DEVELOPMENT REVIEW BOARD
TRANSPORTATION DEVELOPMENT

DRB Project Number: 1011363
Seven Bar Ranch

SUBJECT: EPC Approved Site Plan for Building Permit

DRB Project Number: 1011363 Hearing Date: 03-14-2018
 Project: Murphy – Seven Bar Ranch, Lot C-2 Agenda Item No: 7

SHEET NO.  
**C-3.1**

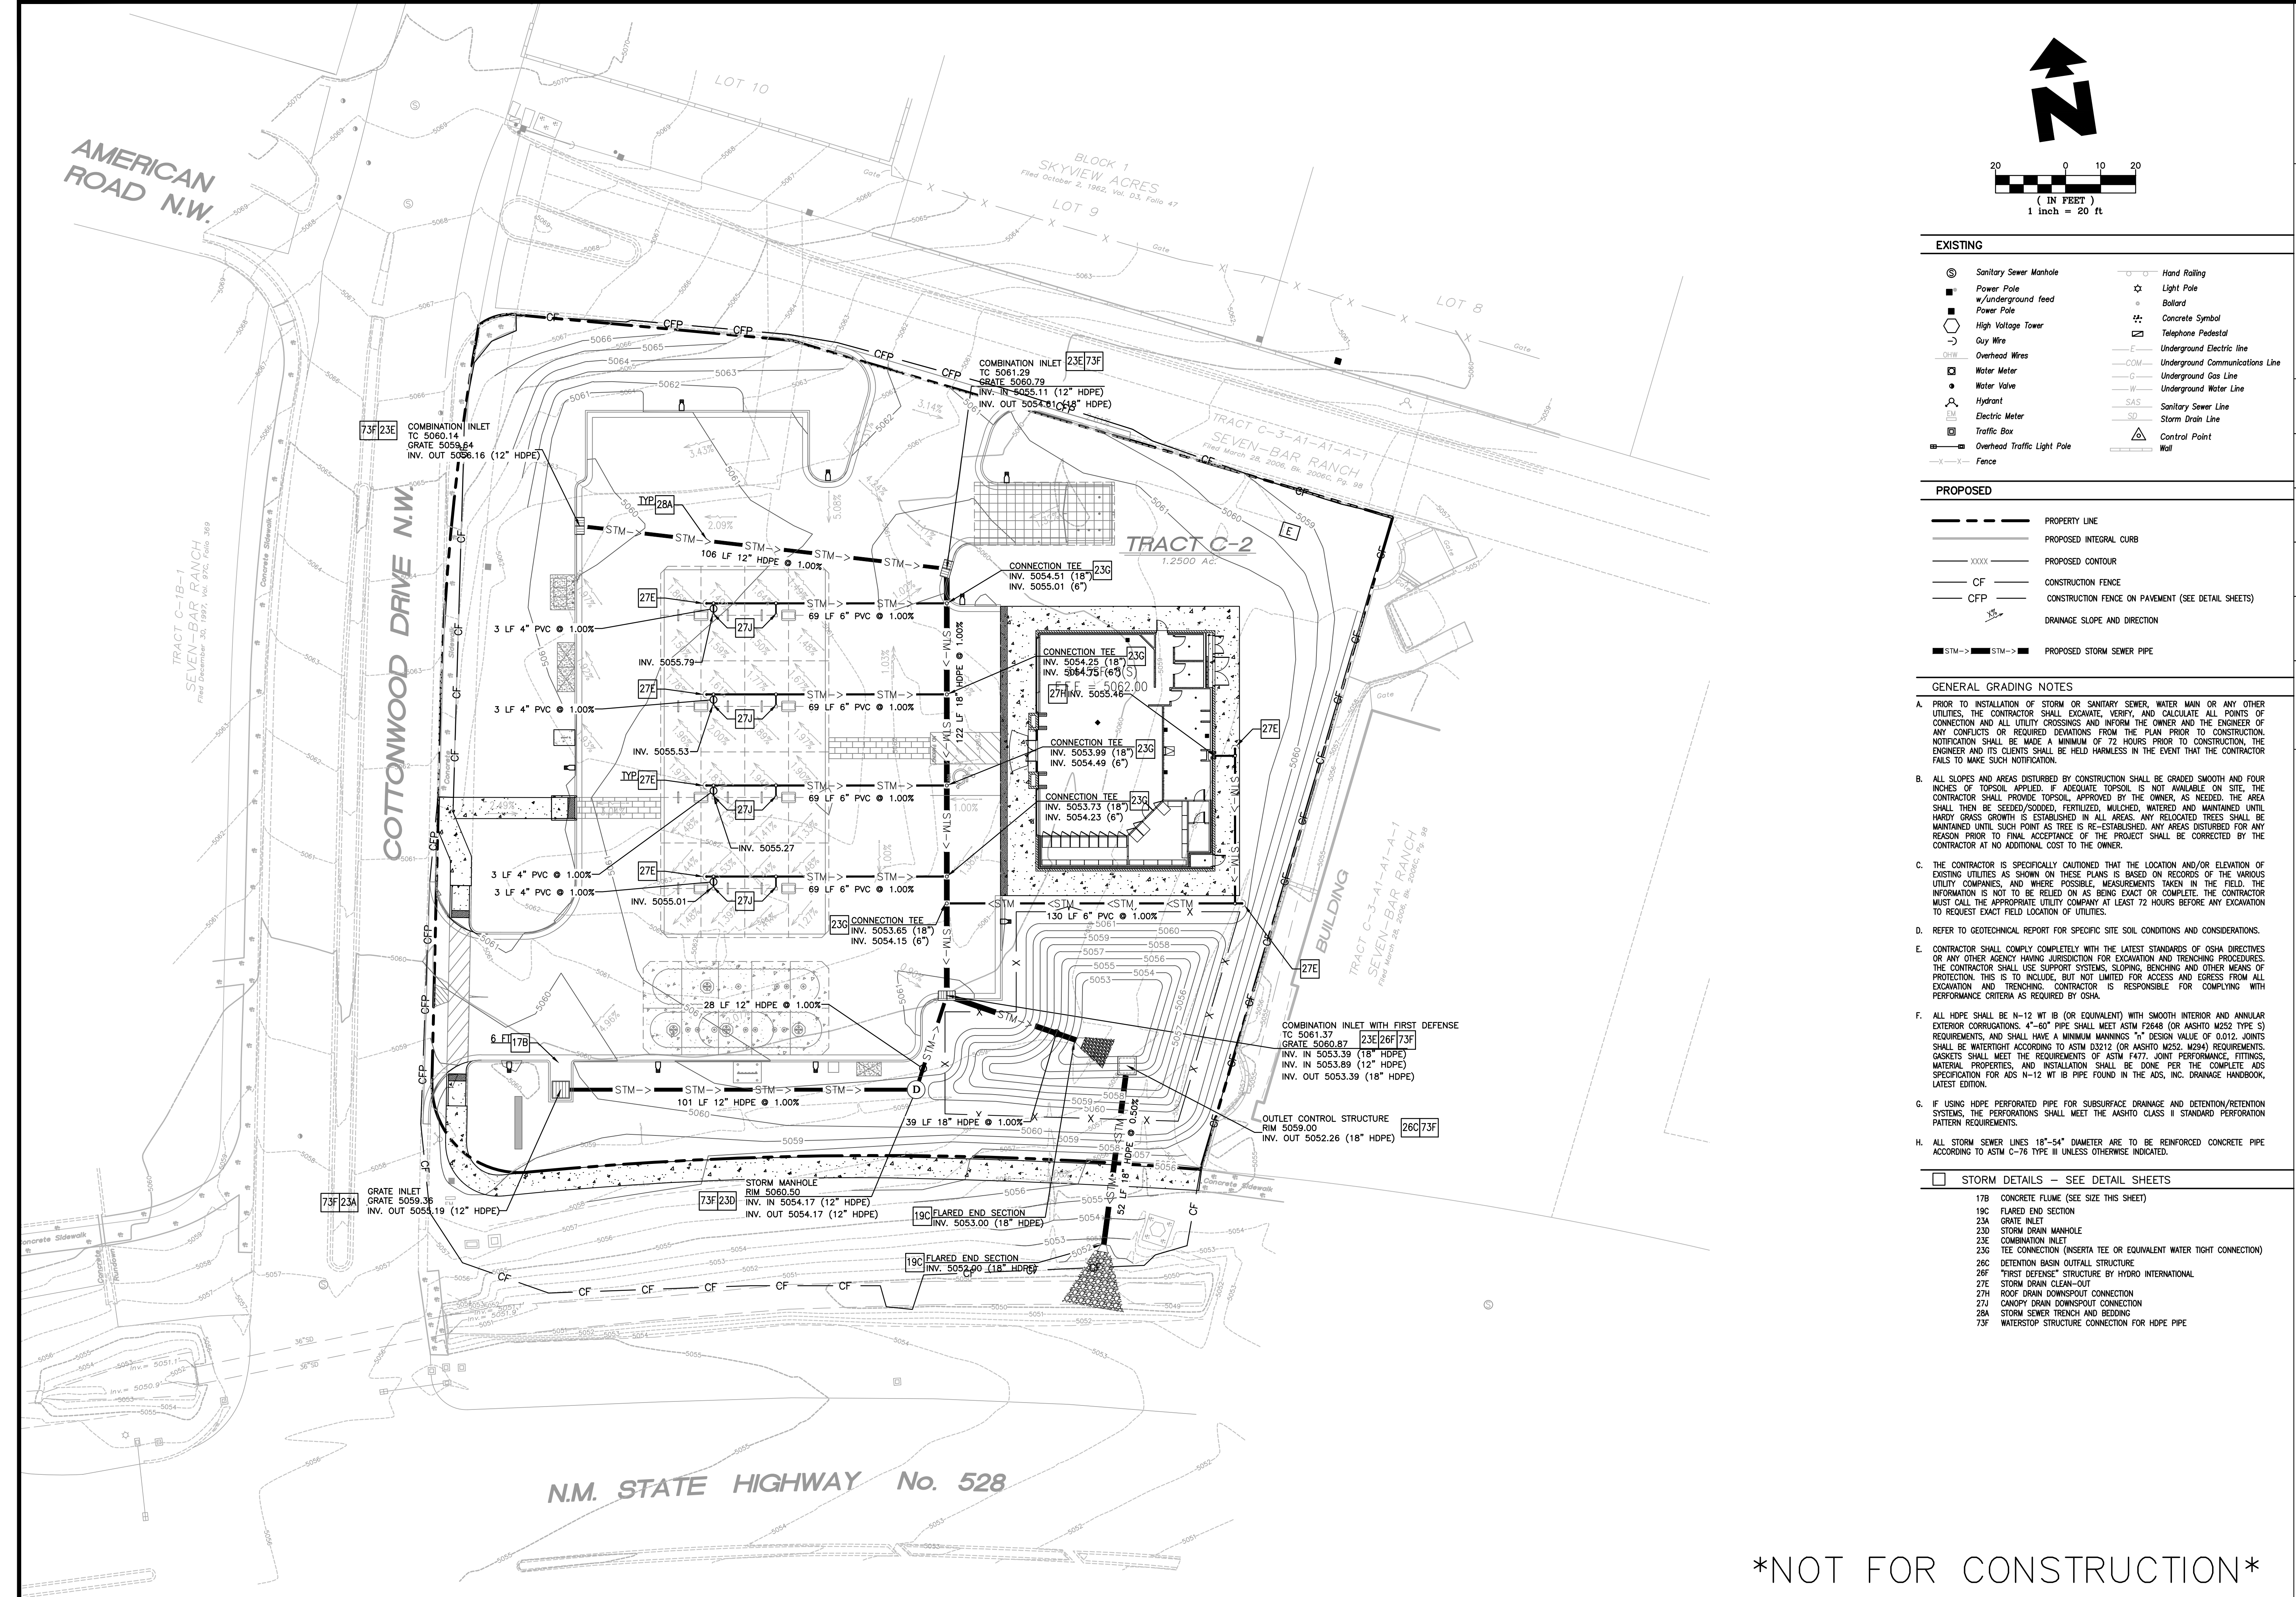
- Hydrology has an approved Conceptual Grading Plan with Revision 3 date 1/23/18 for Site Plan for Building Permit.
- If layout changed per DRB comments on 2-14-18, then new Conceptual Grading Plan will need to be approved.
